COUNTY COUNCIL'S RESPONSE TO CONSULTATION ON THE FOLLOWING DEVELOPMENT PROPOSAL

Application No: 19/00963/OUT

Proposal: Re-submission of application 17/02394/OUT - Outline planning permission for up to 55 dwellings with associated landscaping, open space and vehicular access off Berry Hill Road.

Location: East Of Last House Adjoining And North Of Berry Hill Road, Adderbury

SITE ACCESS JUNCTION @ 1:1250 SCALE

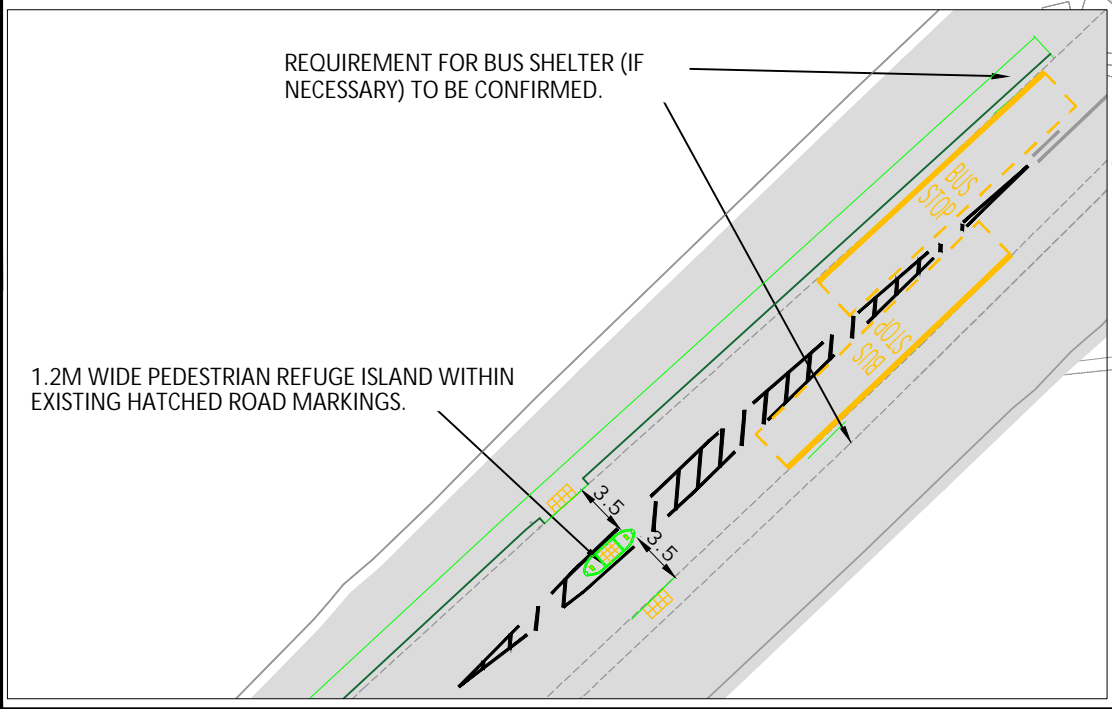
- Proposals relate to a previously approved access arrangement (Drawing No. 1899-F01 Rev C) but this has not been submitted with this application.

It is picked up from a supporting document entitled "Response to Highway Comments - April 2018" that there has been a later version of the site access arrangements referenced by **Drwg No: 1899-F01 Rev C** whose details have been agreed with the Highway Authority. The site access drawing presented as part of this application is however a different version referenced as **Drwg No: 1899-F01 Rev B**.

but the corresponding TS has not been updated to reflect those changes. As such, the updated proposals (as written in the “Response to Highway Comments – Feb 2018” and subsequent “Response to Highway Comments - April 2018”) do not correspond to the TS submitted in support of this application. This application being outline, seeking planning permission on the general principles must clearly present the right access arrangement for review. Without this, the application cannot be supported. **(Reason for objection)**

- A pair of bus stops (hardstanding's) to be provided near to the proposed site entrance / exit on Berry Hill Road to be served by the current S4 bus service.
- Provision of the site access, pedestrian footways, and pedestrian crossing as shall be shown by a plan agreed to with the Highway Authority.

Prior to the commencement of the development hereby approved, full details of the means of access between the land and the highway, including, position, layout, construction, drainage and vision splays shall be submitted to and approved in writing by the Local Planning Authority. Thereafter, the means of access shall be constructed and retained in accordance with the approved details.
